Section 73 Application for the Variation of Condition 2 of 2021/48/93190/E following Full Planning Permission for Alterations to the Building and Material Change of Use of Units to Flexible Uses falling within Use Classes E(a), (b), (c), (d), (g[i]), (g[iii]), Public House / Wine Bar / Drinking Establishment

At 1-22 The Arcade, 14 & 16 Corporation Street and 23 & 25 Market Place, Dewsbury WF13 1QG

BDP is instructed by our client, Kirklees Council, to seek the variation of condition 2 of full planning permission 2021/48/93190/E, to regularise amendments to the proposal since the original permission was granted.

Ground Floor Removals Plan

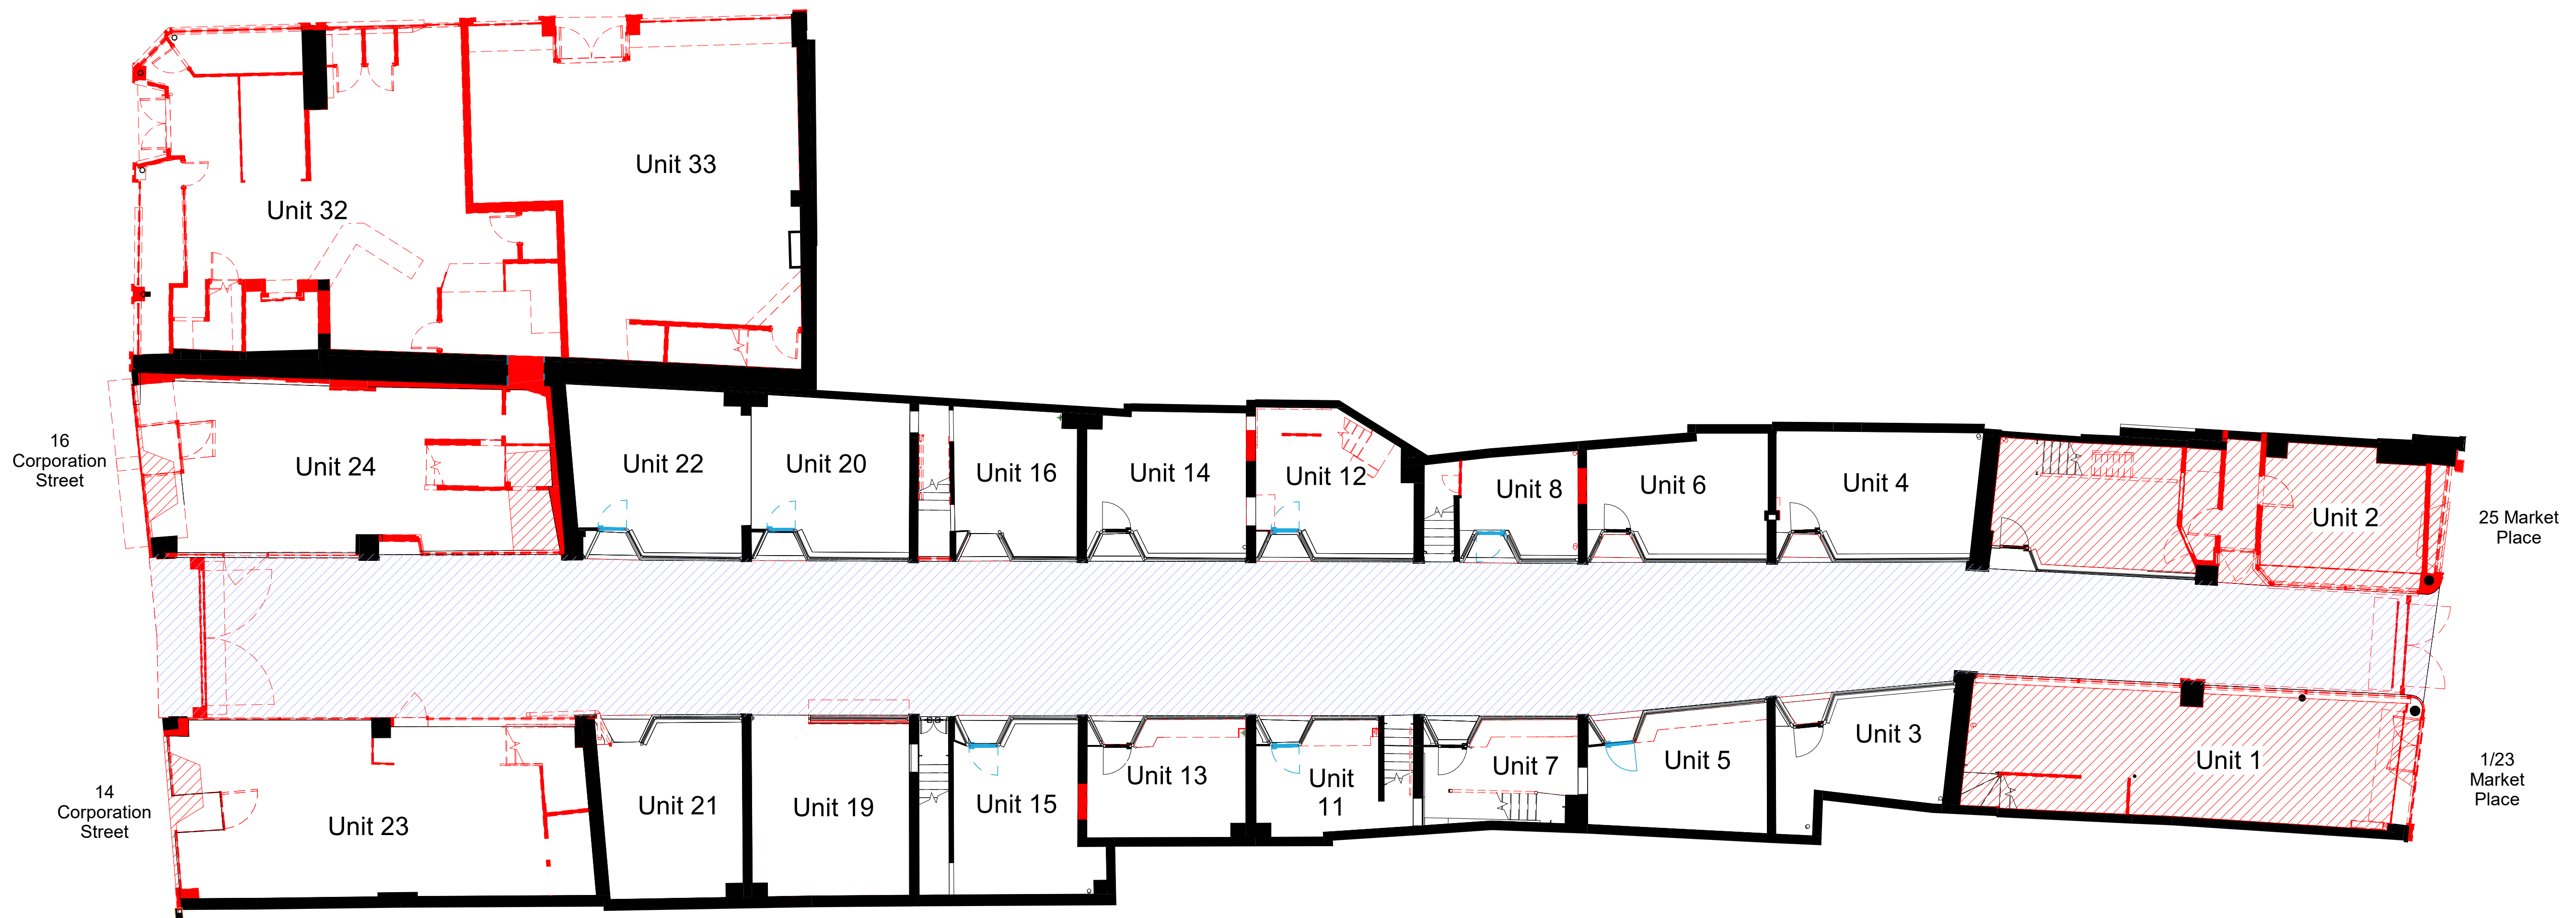
Third Floor GA Plan as Proposed 1705-BDP-AD-03-PL-A-20001 P01	1705-BDP-AD-03-PL-A-20001 T01*	Top of the lift shaft in Unit 30a removed.
Roof GA Plan as Proposed 1705-BDP-AD-RF-PL-A-20005 P01	n/a	To remain as previously approved
Removals Plans		
Ground Floor Removals Plan 1705-BDP-AD-00-PL-A-20002 P01	1705-BDP-AD-00-PL-A-20002 T01*	Staircase in Unit 2 to be removed. Removal of existing slab in Units 1 and 2. Structural Surveys have identified that the basement structures in Market Place are heavily corroded and require replacement - with new beam and block floors. This information was not available at the time of the original applications. Removal of small area of existing floor in Unit 24.
First Floor Removals Plan 1705-BDP-AD-01-PL-A-20002 P01	1705-BDP-AD-01-PL-A-20002 T01*	Floor removal for the lift and stair core in Unit 26 no longer necessary. Existing staircases in Units 25 and 26 to be removed and floor infilled. Existing temporary floors in Units 18a and 18c identified, to be replaced.

BDP JOB NUMBER
P3001705
DRAWING TITLE
Second Floor Removals Plan

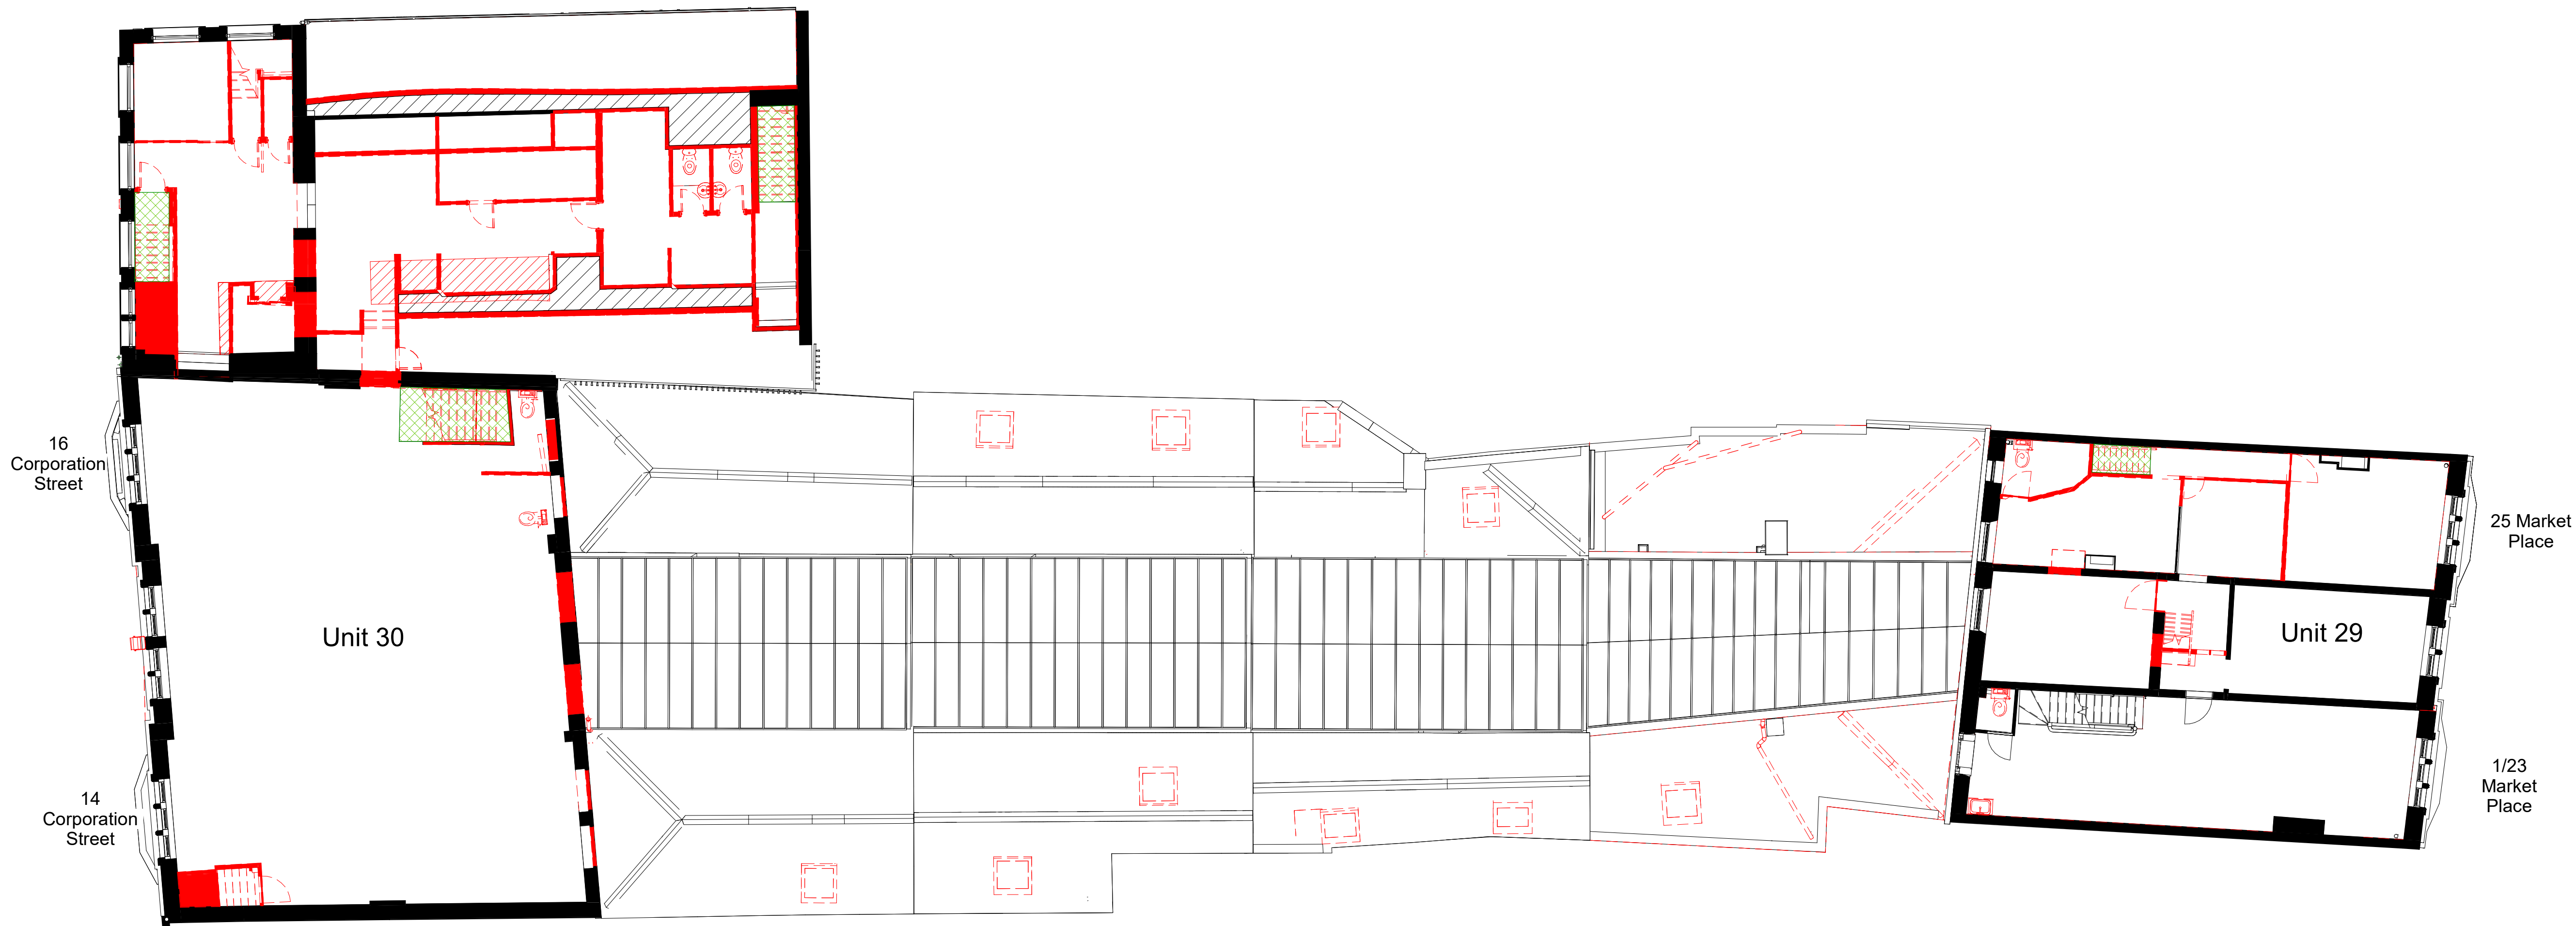
Second Floor Removals Plan 1705-BDP-AD-02-PL-A-20002 P01	1705-BDP-AD-02-PL-A-20002 T01*	Floor removal for the lift and stair core in Unit 30 no longer necessary. Existing staircase in Unit 30 to be removed and floor infilled.
Third Floor Removals Plan 1705-BDP-AD-03-PL-A-20002 P01	1705-BDP-AD-03-PL-A-20002 T01*	Floor removal for the top of the lift core in Unit 30a no longer necessary. Existing staircase in Unit 30a to be removed and floor infilled.
Sections and Elevations		
North Elevation 1705-BDP-AD-XX-EL-A-20001 P01	n/a	To remain as previously approved
South Elevation 1705-BDP-AD-XX-EL-A-20002 P01	n/a	To remain as previously approved
East Elevation 1705-BDP-AD-XX-EL-A-20003 P01	1705-BDP-AD-XX-EL-A-20005 T01	Internal partitions removed on second floor. Larger accessible WC door no longer required for Unit 16 – original arrangement to be retained.
West Elevation 705-BDP-AD-XX-EL-A-20004 P01	n/a	To remain as previously approved
